**KIRKLEES METROPOLITAN COUNCIL
INVESTMENT & REGENERATION SERVICE**

**DELEGATED DECISION TO DETERMINE APPLICATIONS FOR
CONSENT, AGREEMENT OR APPROVAL REQUIRED BY CONDITION**

Reference No: 2018/44/93395/W

Description: Discharge of condition 8 (outdoor lighting) on previous premission 2015/91261 for erection of 2 storey annex forming 4 residential respite care apartments

PROPOSED FRONT ELEVATION (FROM ROYD STREET)
SCALE 1:100 AT A3

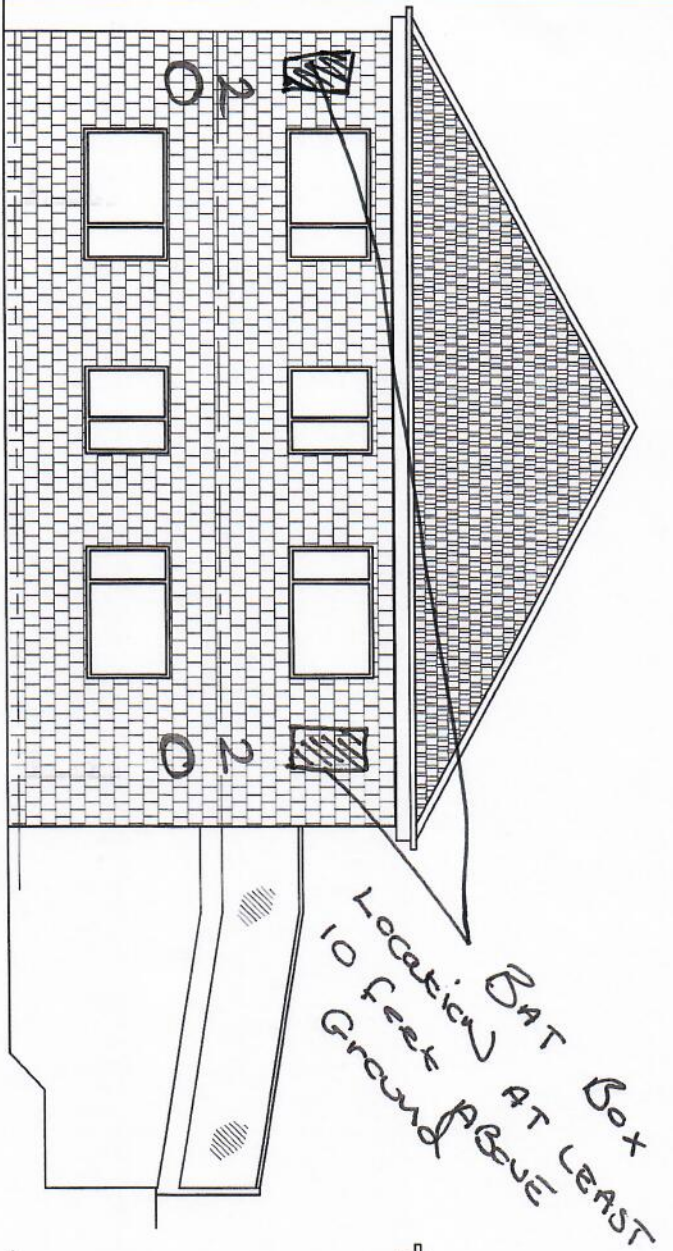
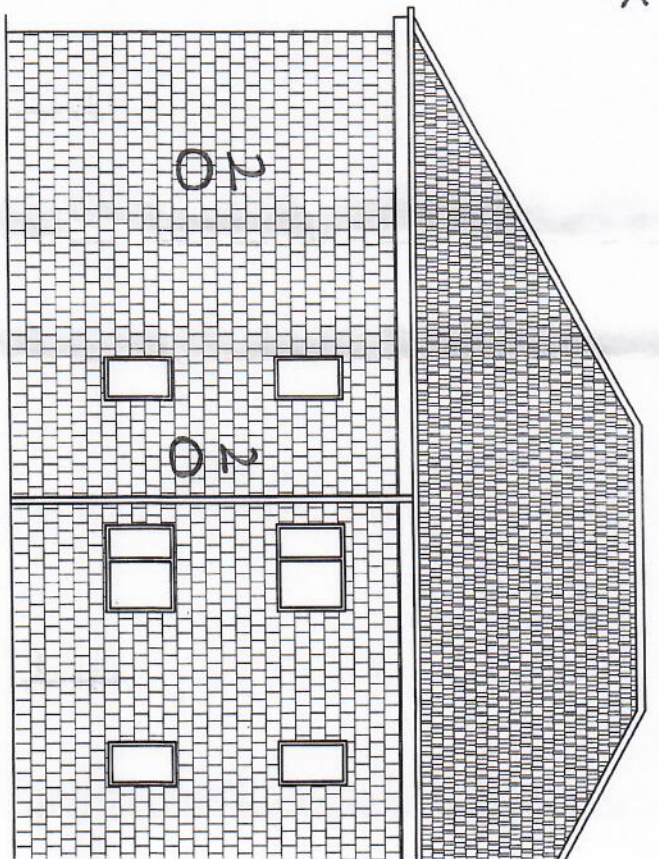
The submitted plan shows the position of two bat boxes relative to a number of lights on the four elevations of the building. This is acceptable to the Biodiversity Officer subject to minor amendment.

These details are acceptable subject to the amended location of the lights in accordance with the enclosed drawing.
